PLANNING CONSULTATION RESPONSE

Application No	2025/0610
Proposal	Outline development of five residential dwellings and associated infrastructure considering access and scale.
Address	Vernon House, Yews Lane, Kendray, Barnsley, S70 3LJ
Date of Consultation Reply	16 th October 2025
Consultee	Highways DC

[2nd Response – Amended plans]

Title
SITE ACCESS & PROPOSED LEVELS

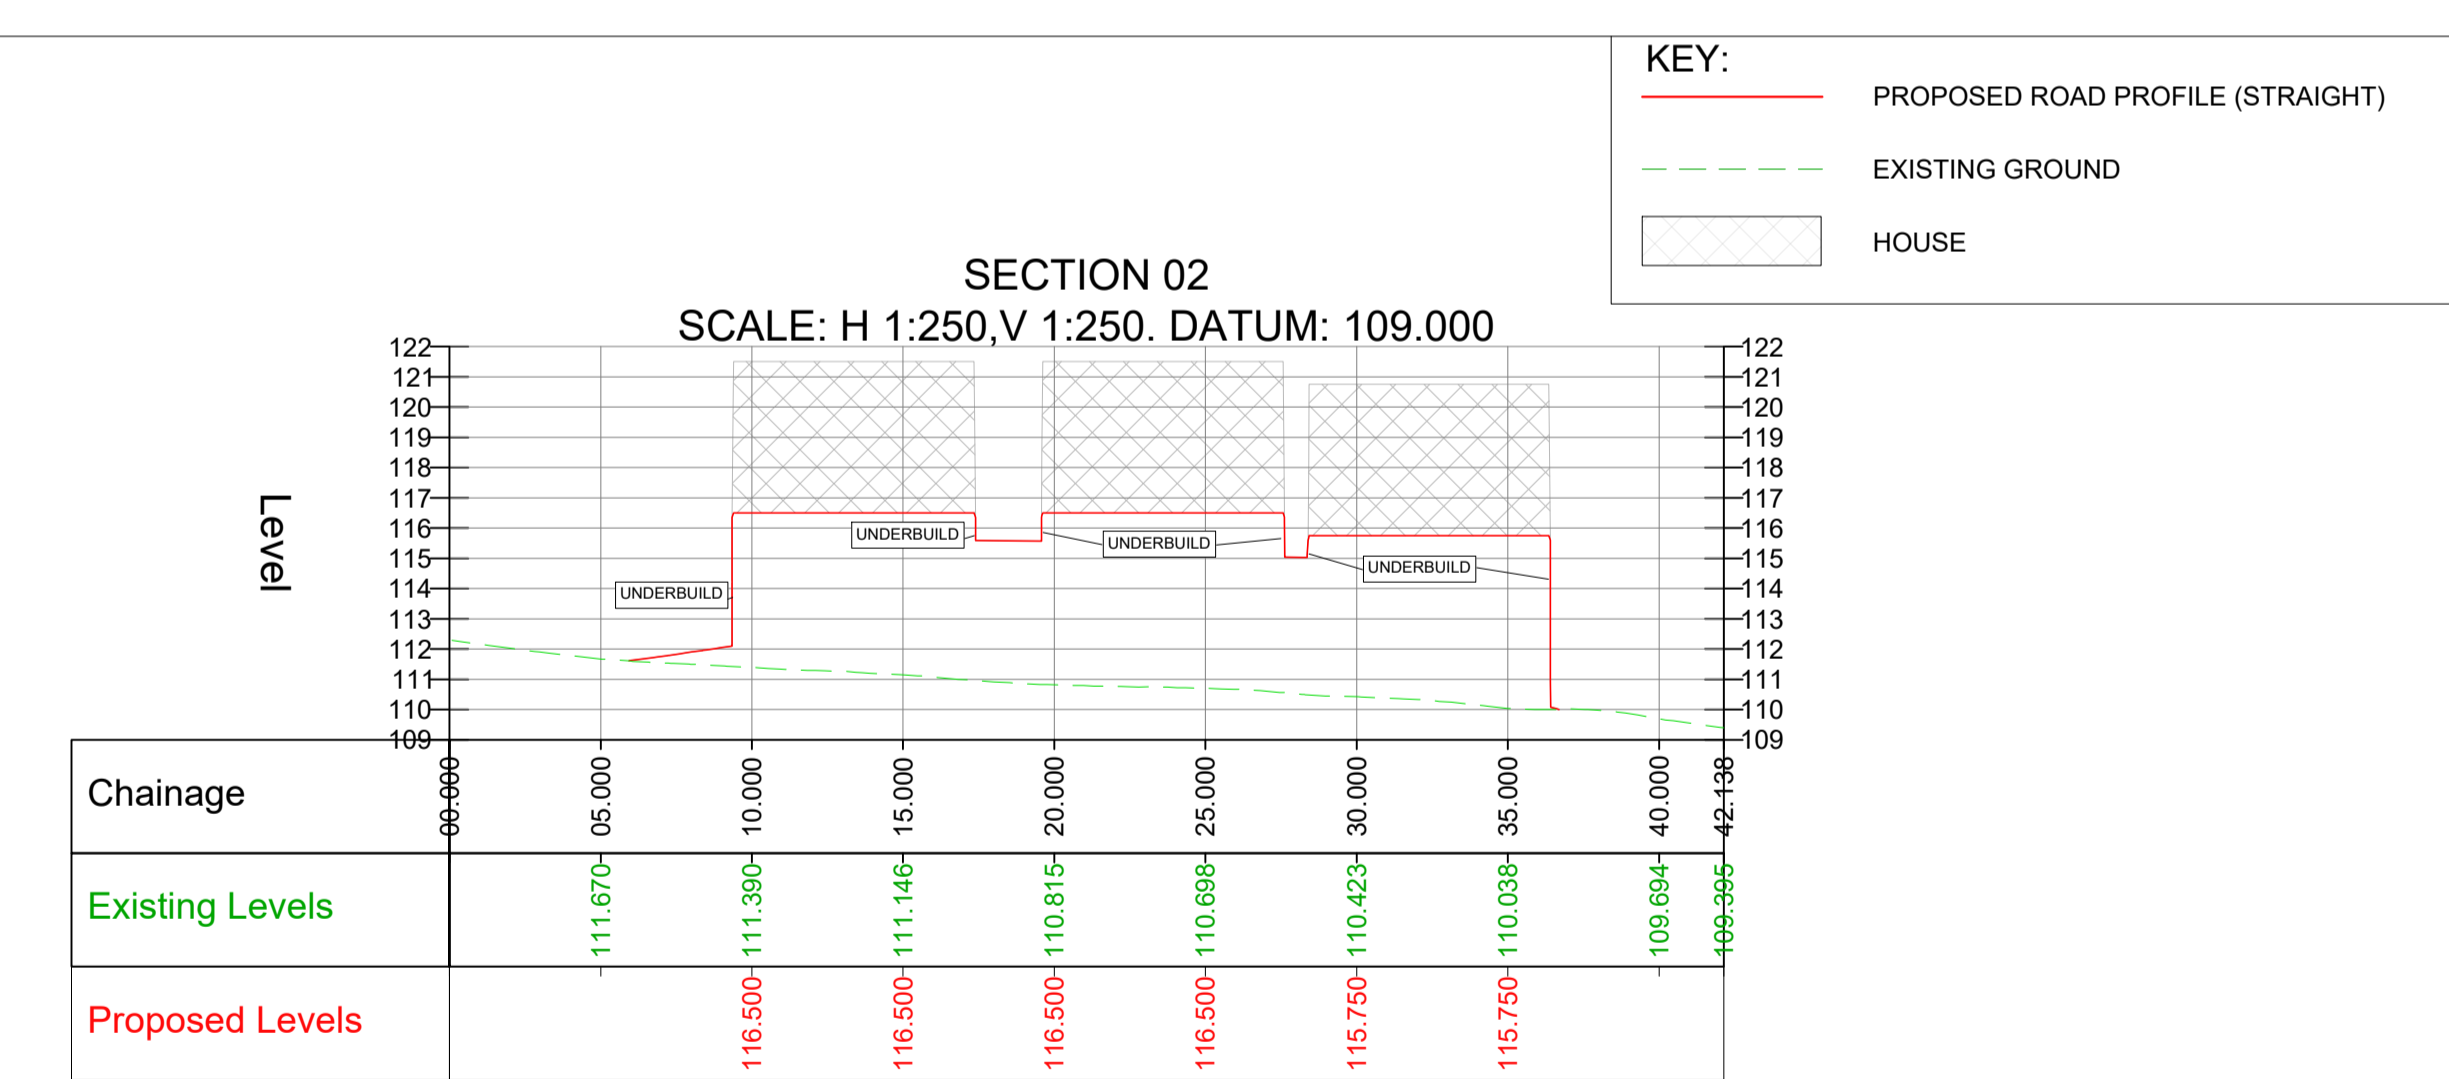
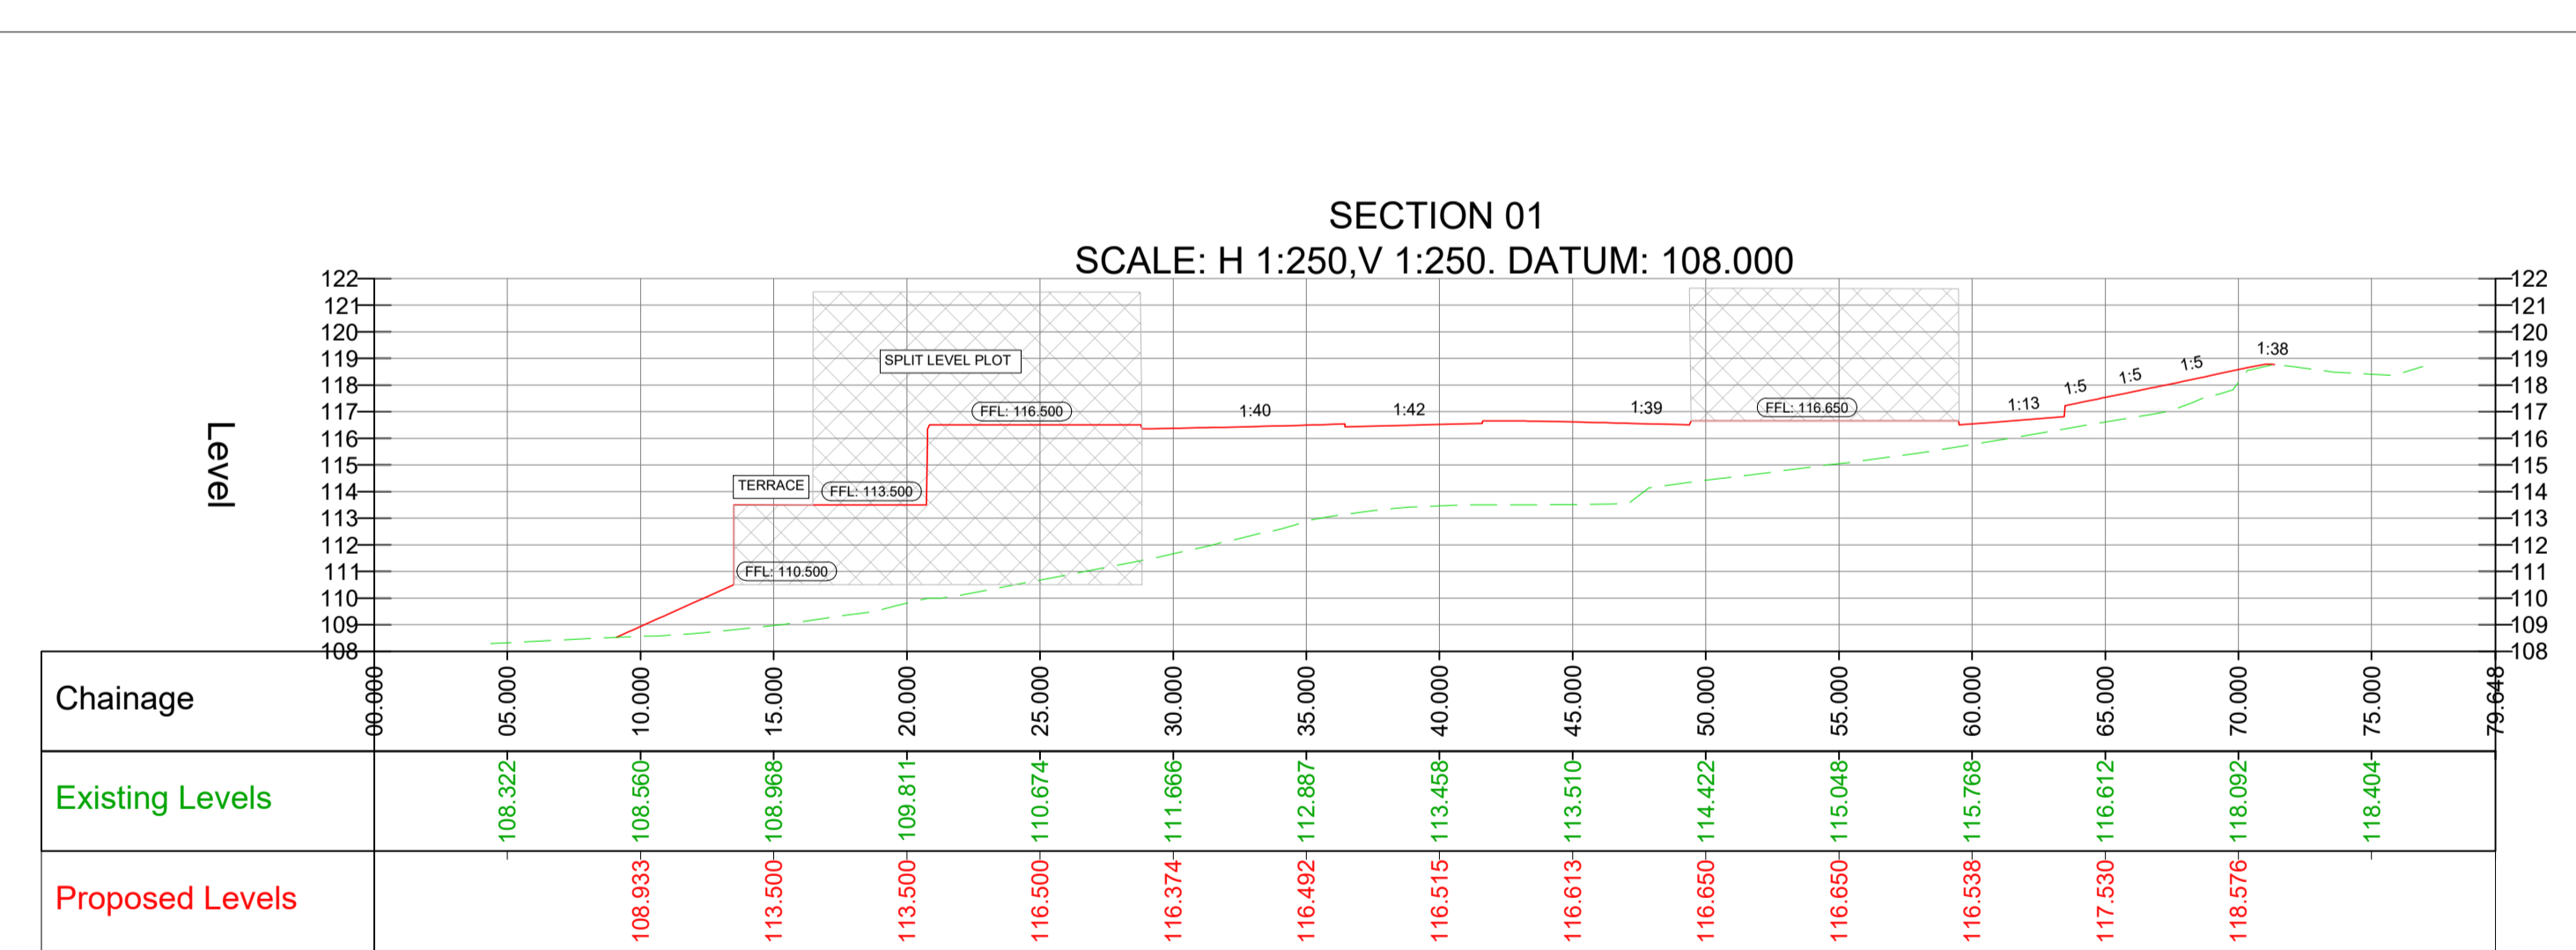
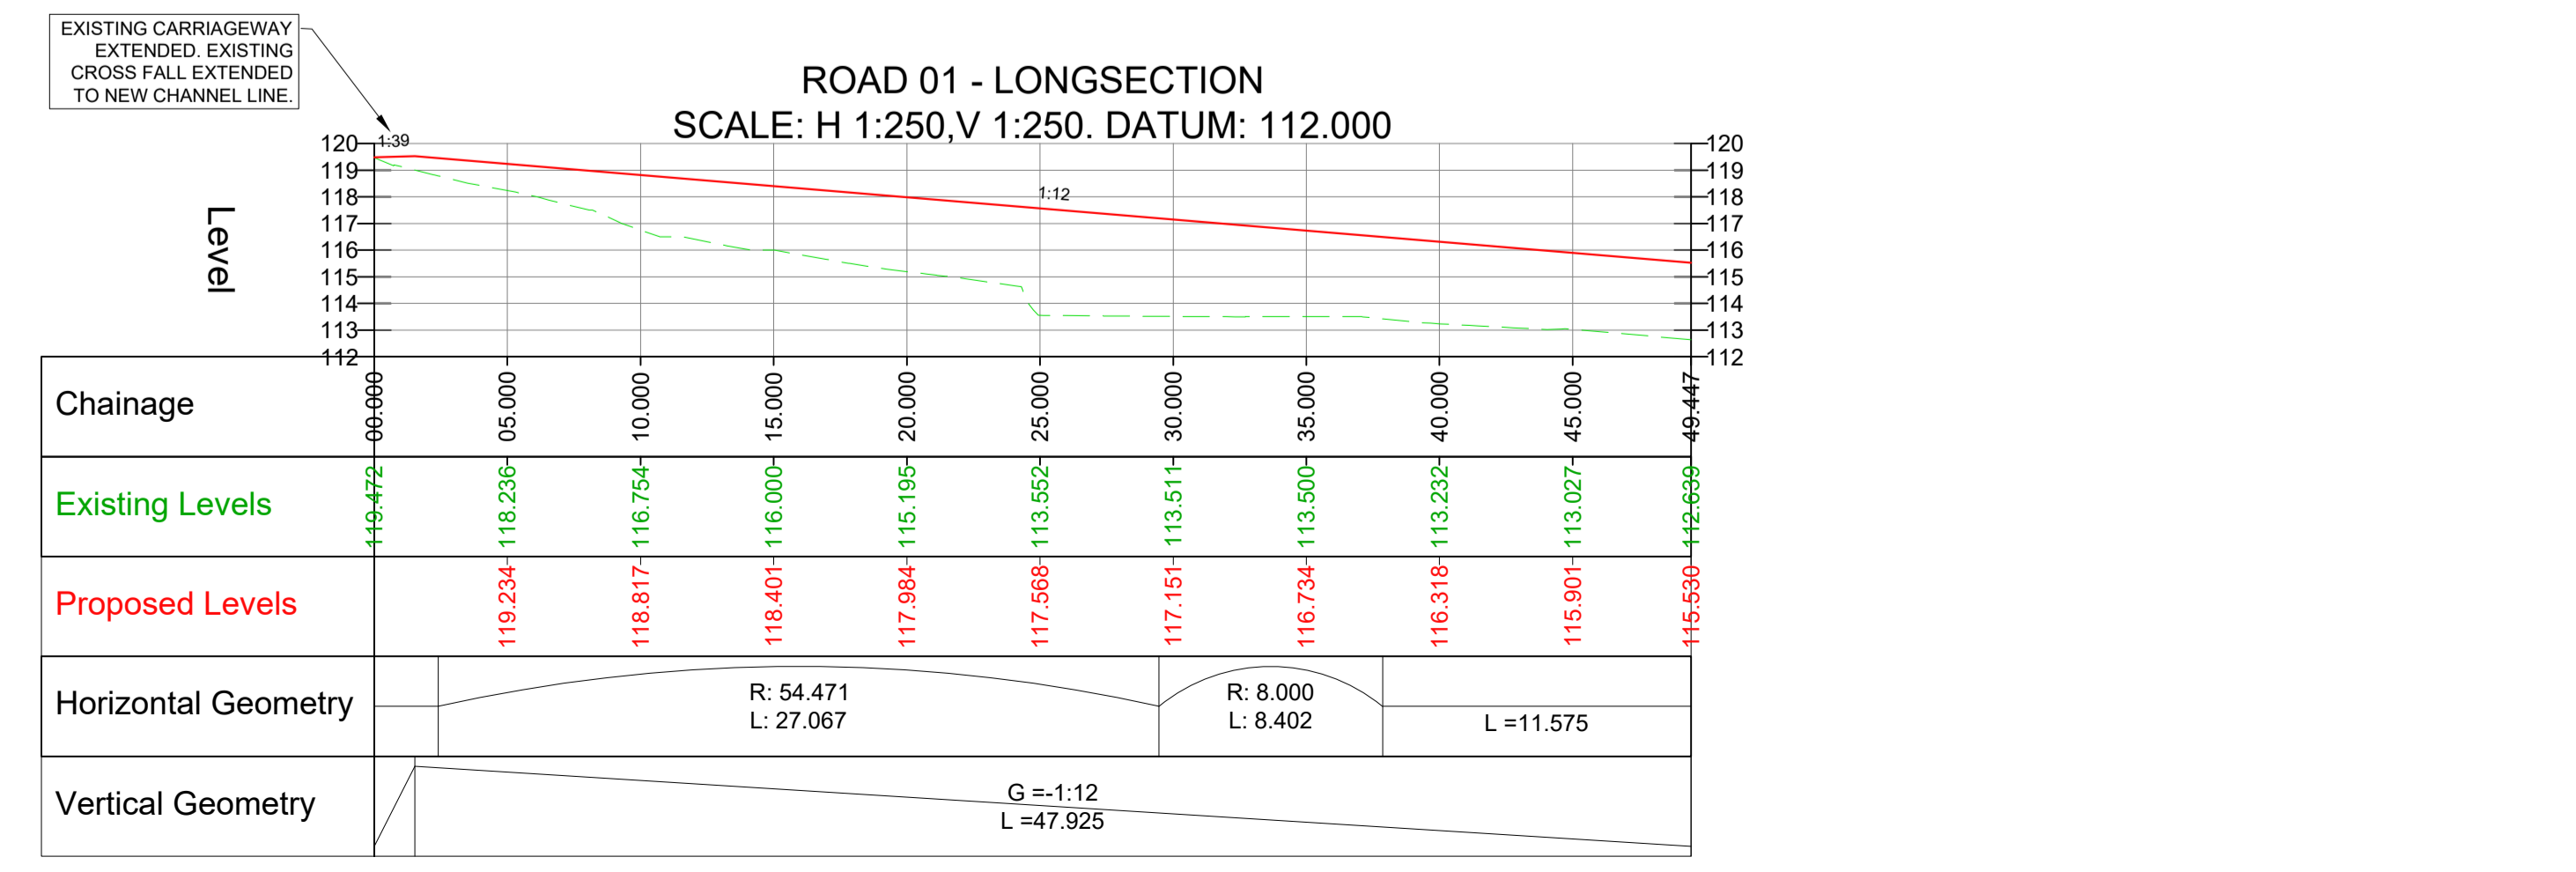
The proposed bin store is now positioned slightly further into the site so as not to impede visibility. The 'Site Access and Proposed Levels' drawing now shows that the proposed access road is to have a gradient of 1:12. The access has a width of 4.5m which is sufficient for two vehicles to pass.

The gradient of areas for vehicular and pedestrian use shall not exceed 1 in 12.

Indicative Site Layout

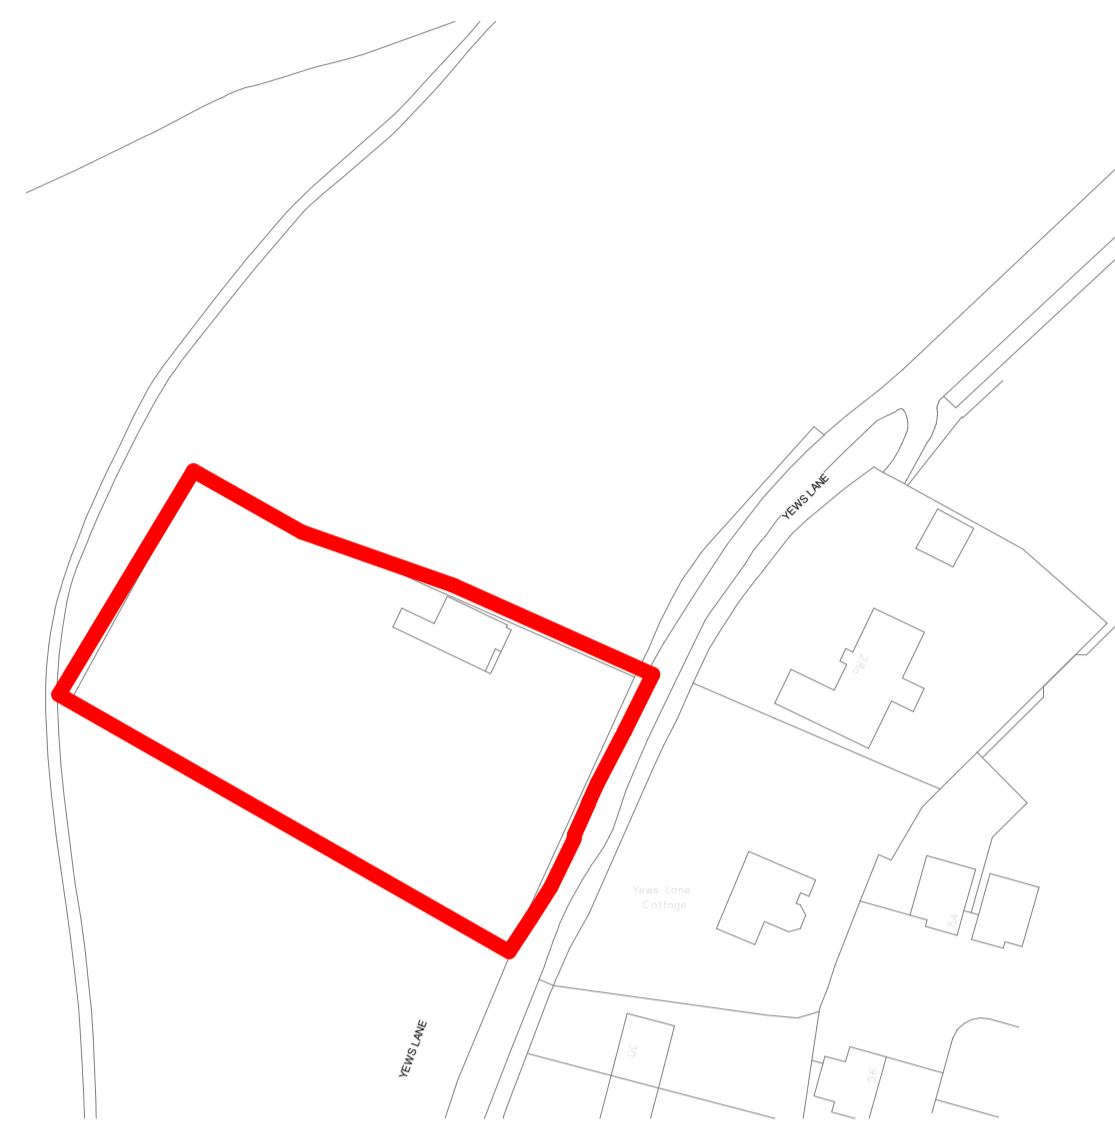
I am aware that Access and Scale are the only matters put forward for consideration at this time, however, I note that the submitted plans include an indicative layout which would not be considered acceptable from a highways point of view. As such, the following comments may prove useful at reserved matters stage:

- The layout includes two parking spaces of satisfactory size for each dwelling, however, not all of the spaces have a clear 6m of manoeuvring space to allow adequate access/egress.

- There is no provision for visitor parking within the site; the Barnsley Supplementary Planning Document (SPD) Parking (2019) Table 1 states that one visitor parking space should be provided per four dwellings. A minimum of one space should therefore be provided for visitors.

- The turning area is too small to allow a vehicle to turn without utilising the driveway(s) of adjacent dwellings.
- There is no emergency vehicle turning provision within the site; Building Regulations Approved Document B paragraph 13.4 states that "Dead-end access routes longer than 20m require turning facilities".

- With regard to the refuse collection point, the area should be of sufficient size to house the maximum number of receptacles for all properties served from the shared private drive. It should be noted that the Building Regulations relating to refuse distances are as follows:
Maximum distance for carrying refuse (householder) – 30m (Building Regs H6 1.8)
Maximum distance for moving a wheelie bin (householder) – 25m (Building Regs H6 1.8)
Maximum distance for refuse collector to walk to collect refuse – 15m (BS 5906:2005)
It would appear that the indicative layout requires residents to move their bins a distance exceeding the maximum 25m.
